CITY OF PORTLAND
 FIRE PREVENTION BUREAU
 380 Congress Street, Portland, Maine 04101
 fireprevention@portlandmaine.gov
 (207) 874-8400

NOTICE OF VIOLATION AND ORDER TO CORRECT

Location 572 BRIGHTON AVE	CBL 185 C013001	Inspection Date 3/29/2017
Inspector John Brennan	Inspection Type Legalize Nonconforming units	Status Failed

# 2ND FLOOR RESIDENTIAL

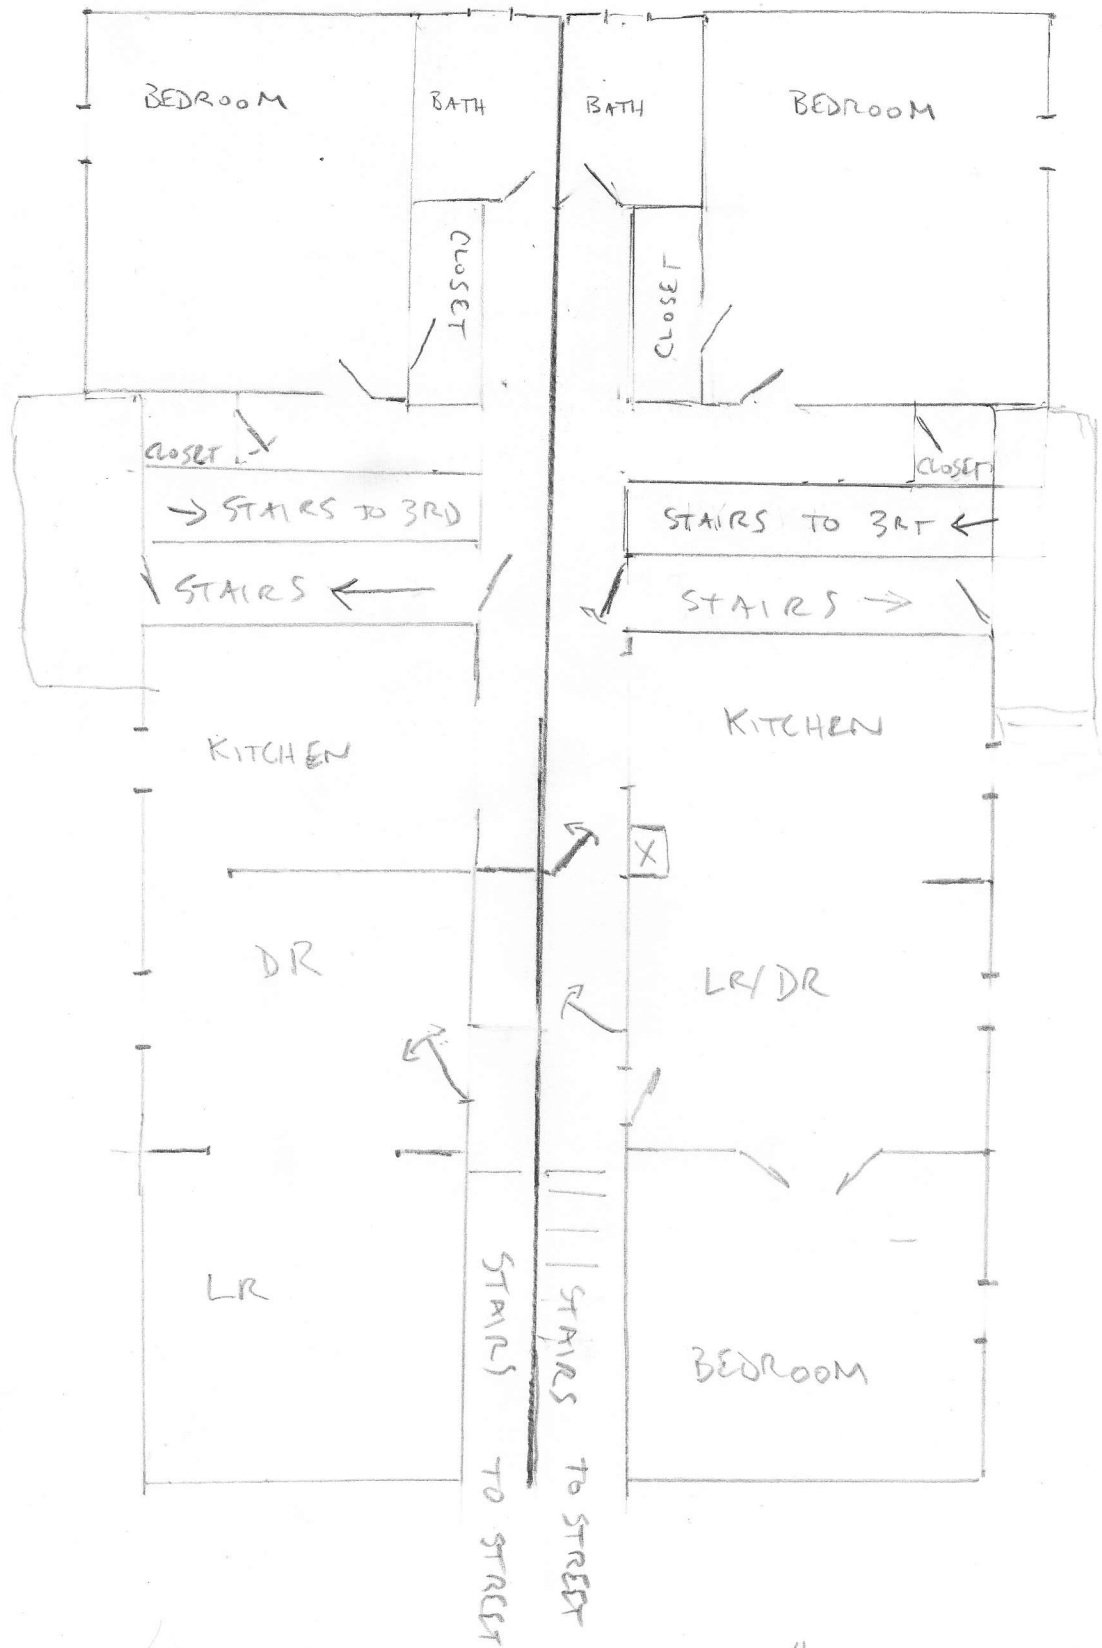
Violation	Proposed Date of Completion
NFPA 70- ARTICLE 110.12 B EXPOSED WIRING CONNECTIONS; Internal parts of electrical equipment, including busbars, wiring terminals, insulators, and other surfaces, shall not be damaged or contaminated by foreign materials such as paint, plaster, cleaners, abrasives, or corrosive residues. There shall be no damaged parts that may adversely affect safe operation or mechanical strength of the equipment such as parts that are broken; bent; cut; or deteriorated by corrosion, chemical reaction, or overheating. Cover old detector wires and opening with a blank plate in Apartment 2W	___ / ___ / ___
NFPA 101- 8.3.4.2 60 MINUTE FIRE DOOR REQUIRED; Refer to NFPA 101- Table 8.3.4.2 that states fire door assemblies for vertical shafts (including stairways, exits, and refuse chutes) are rated and required for 1 hour. Install a fire rated door with self-closing hinges for the extra stairwell door for apartment 2W.	___ / ___ / ___
